Application No: AW/108/21/HH
Site Address: 56 Barrack Lane Aldwick PO21 4DD
Description of works: Erection of two storey extension with balcony following the demolition of existing conservatory, side extension and car port

Thank you for your internet representation made on 15th April 2021 which has been recorded as no objection with the comments as follows:

LOCATION PLAN - 1/1250

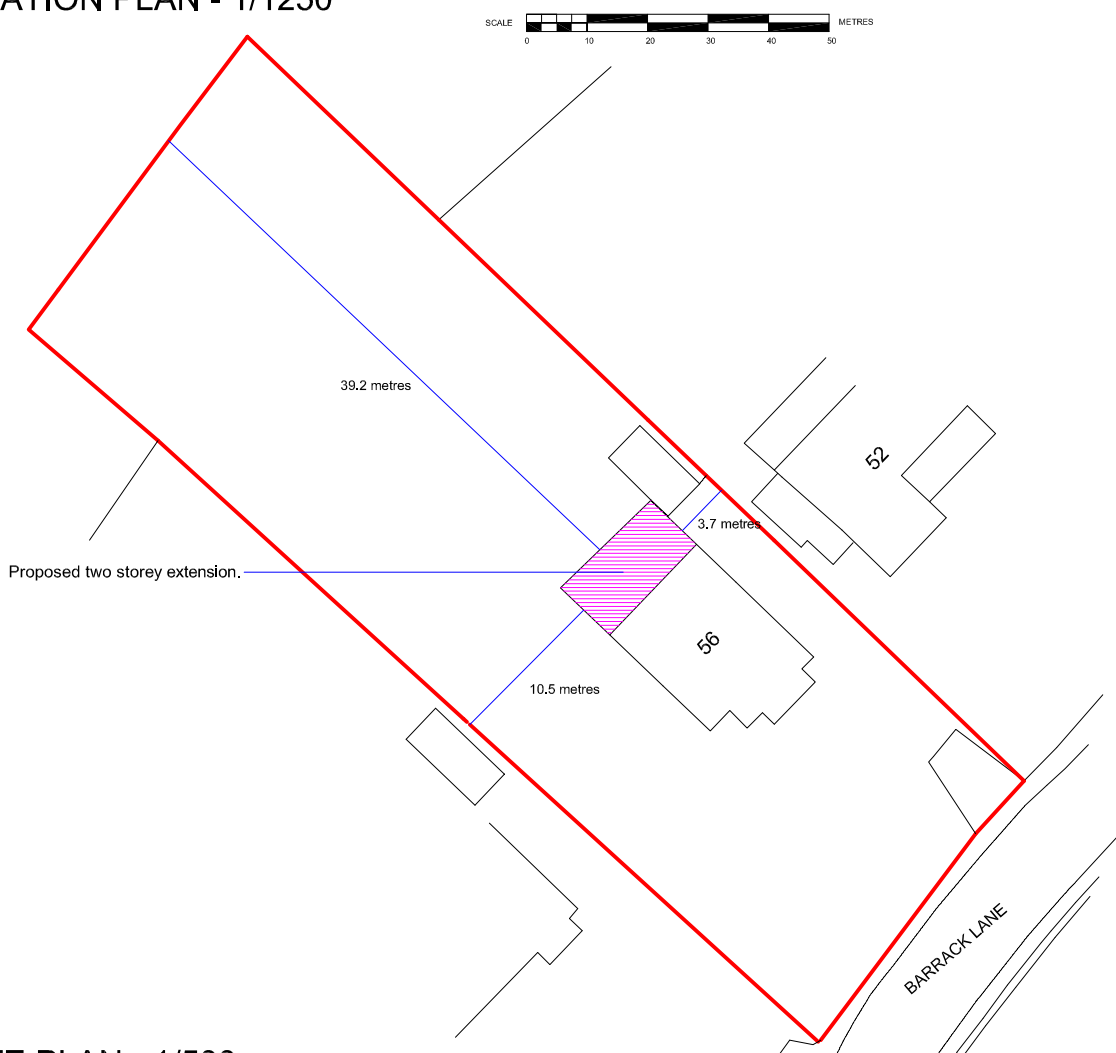
- . The location plan is out of date, surrounding property is missing
- . The rear wall on the Block plan is not at right angles to the sides and is not continuous, there is a small recess/projection to the rear elevation.
- . No car parking provision is indicated
- . No trees are shown.
